# Drainage Report

17115 GOSHAWK ROAD  
COLORADO SPRINGS, CO 80908  
EL PASO COUNTY

January 17, 2019

Engineering Documents  
Reviewed By:  
*Daniel Torres*  
*danieltorres@elpasoco.com*  
EPC Planning & Community  
Development Department

of 05

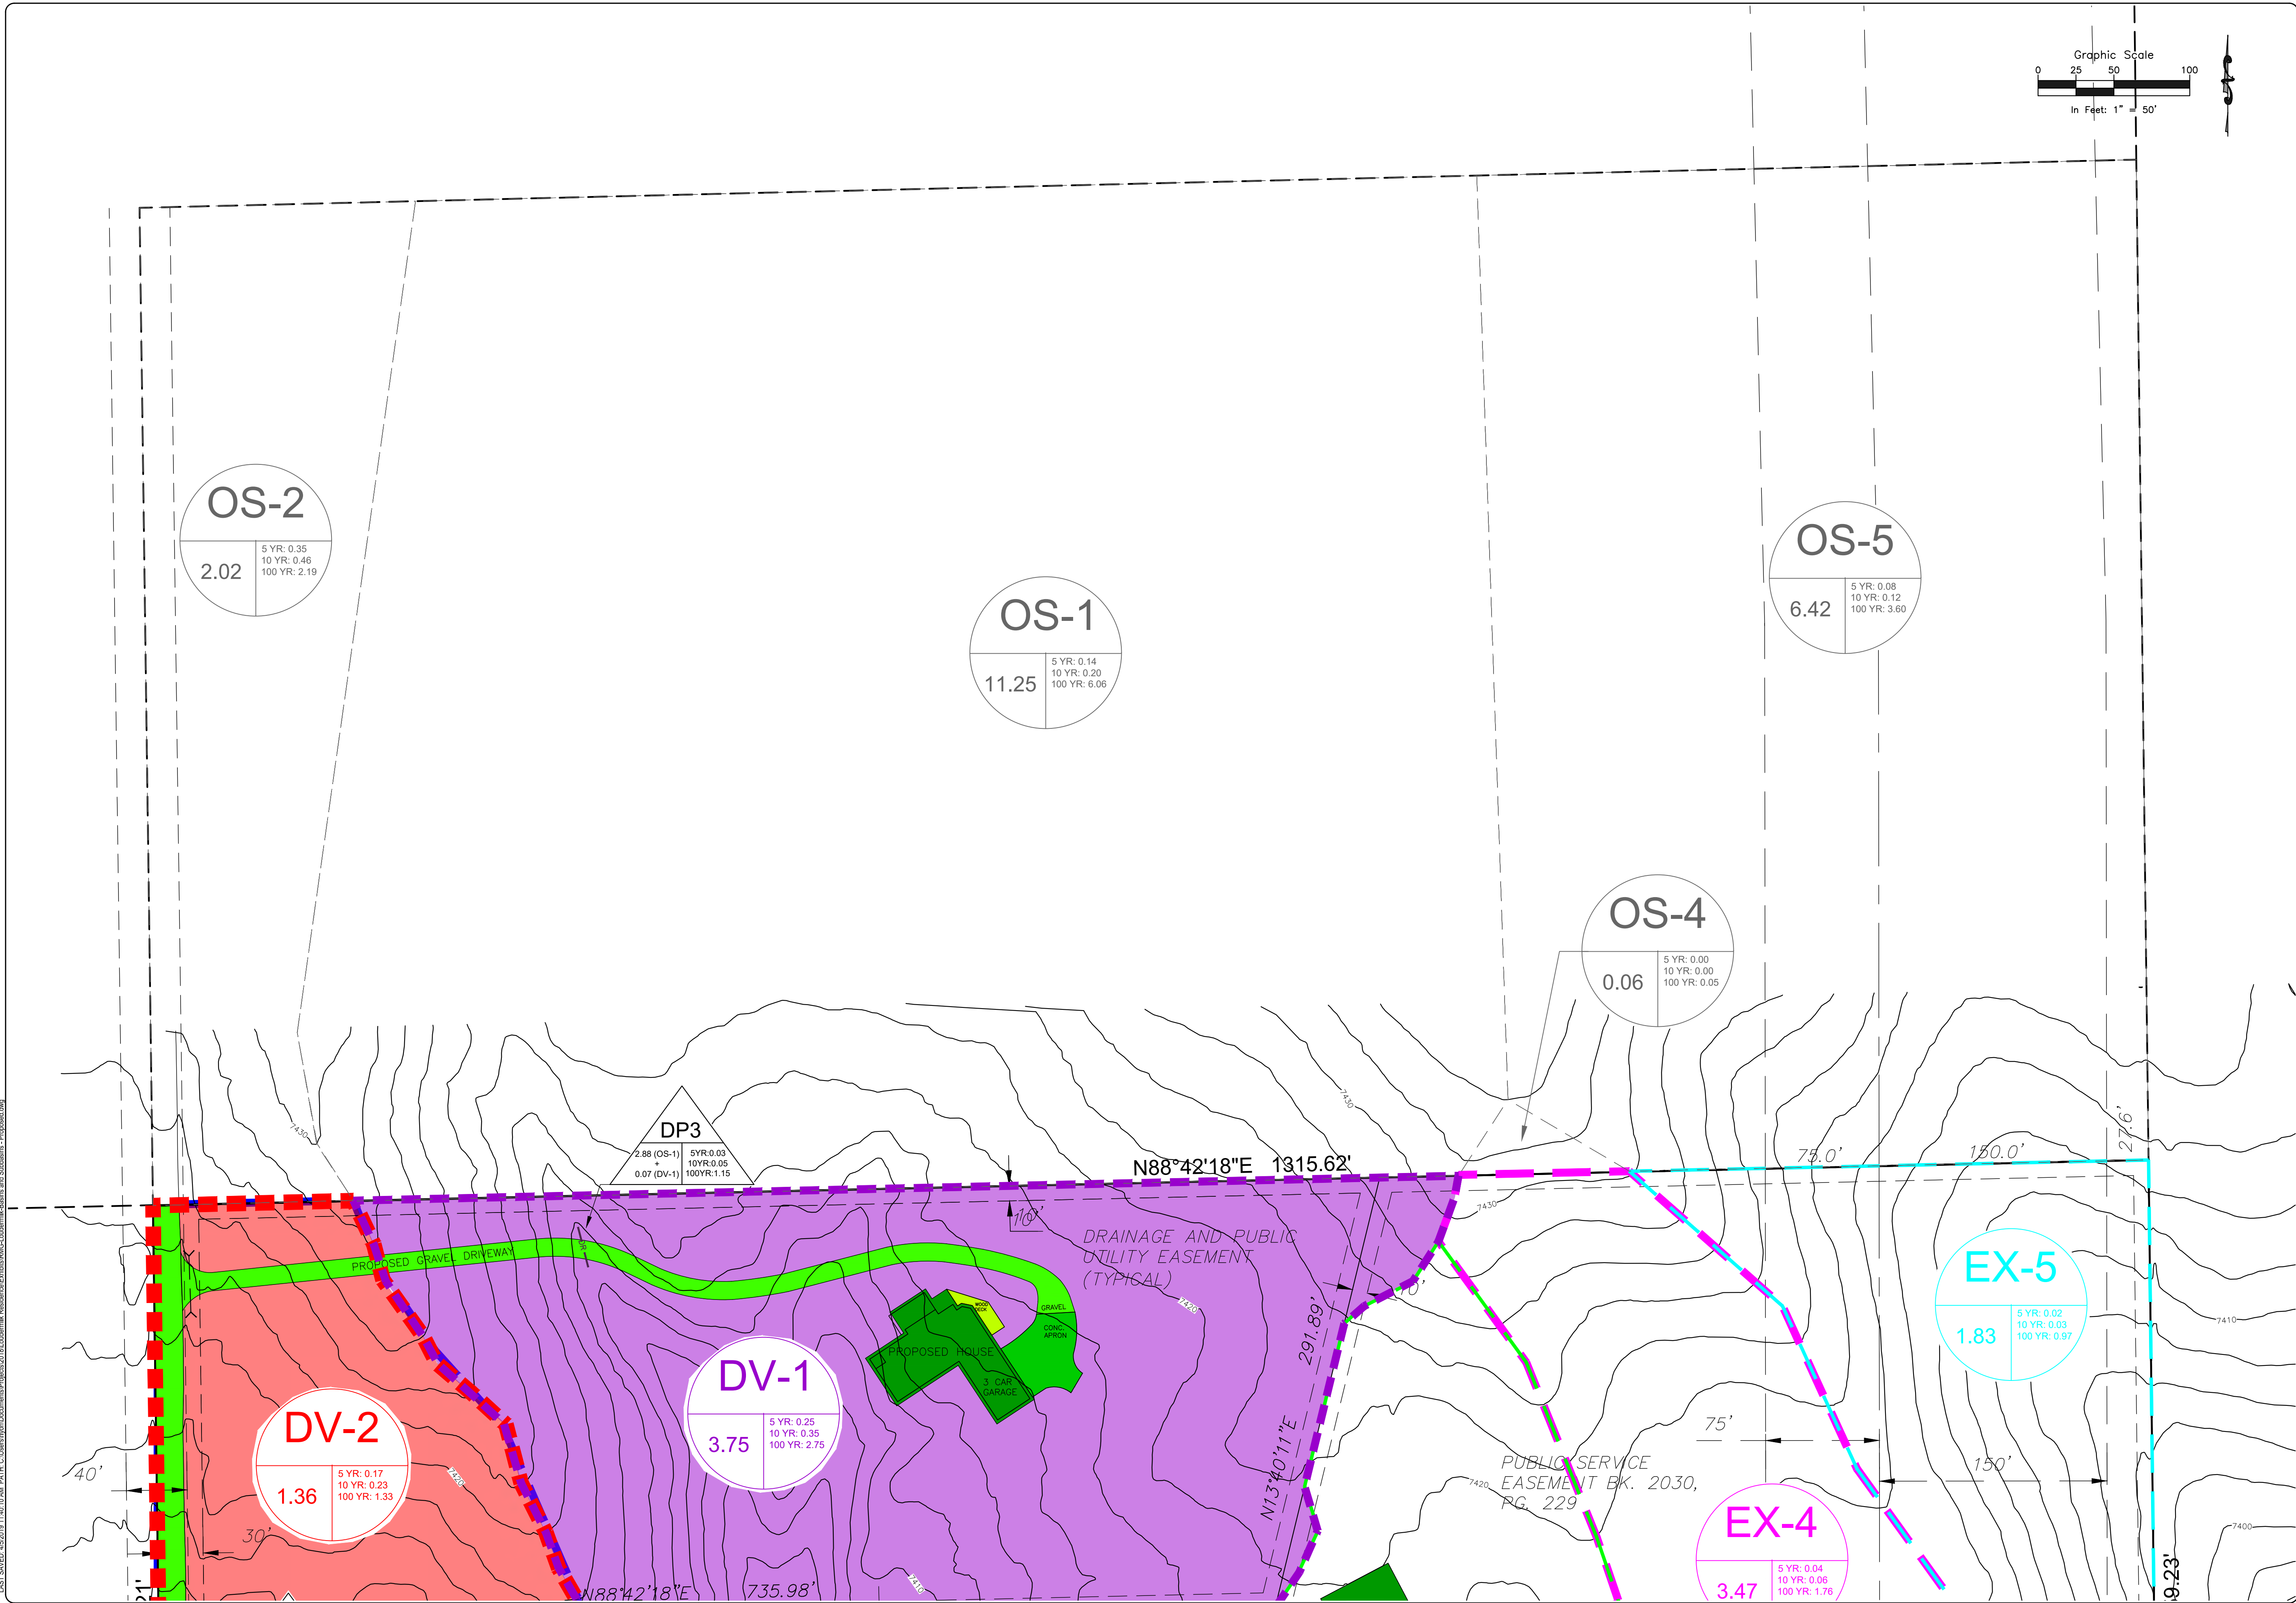
Please indicate the size and type of all culverts and identify them on the drainage plan.

Please indicate the size and type on the drainage plan
